**ANGEL PLACE  
LEVEL 8, 123 PITT STREET  
SYDNEY NSW 2000**

## **ATC SUBMISSION: (SSI-10038) SYDNEY METRO WEST CONCEPT AND STAGE 1**

This submission has been prepared by Urbis on behalf of the Australian Turf Club (**ATC**). The ATC thanks the Department of Planning, Industry and Environment (**DPIE**) for the opportunity to comment on the Sydney Metro West project (**SSI-10038**).

Figure 9-2(b): Indicative alignment plan and long section

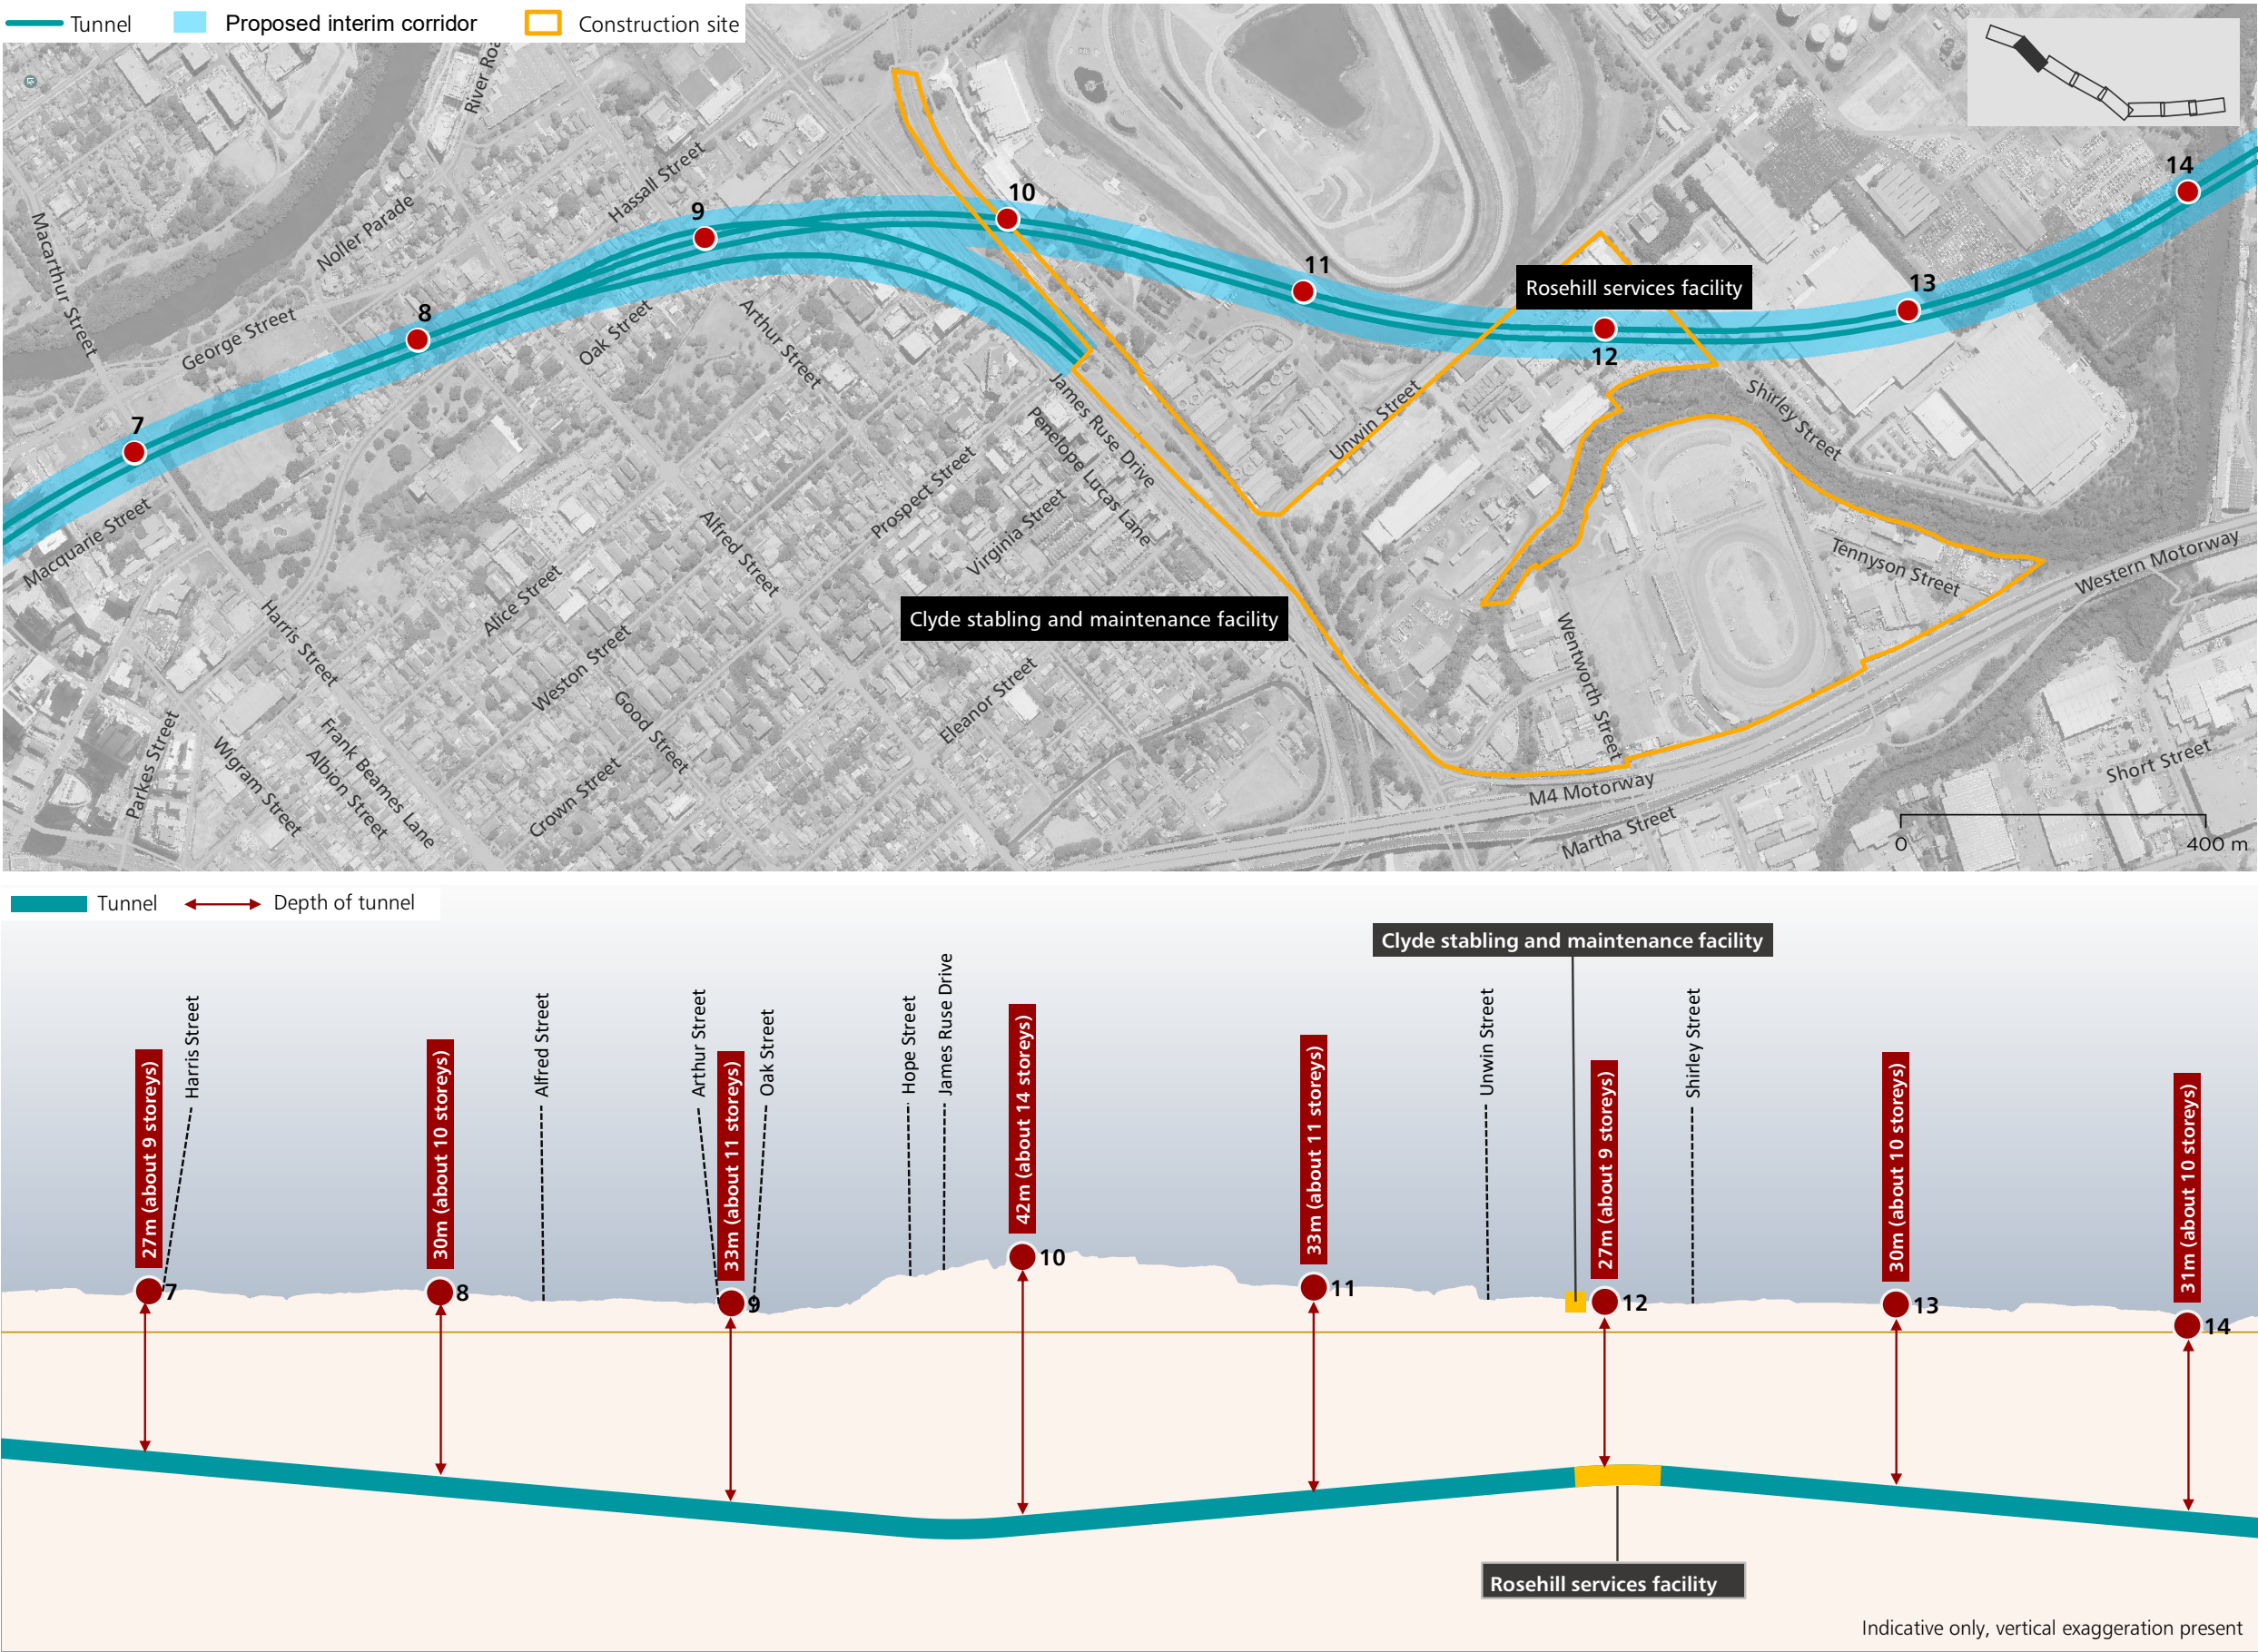
- Tunnel excavations, including under RHG (as shown in Figure 1 and Figure 3). The alignment and depth of the tunnels shown under RHG are indicative only.
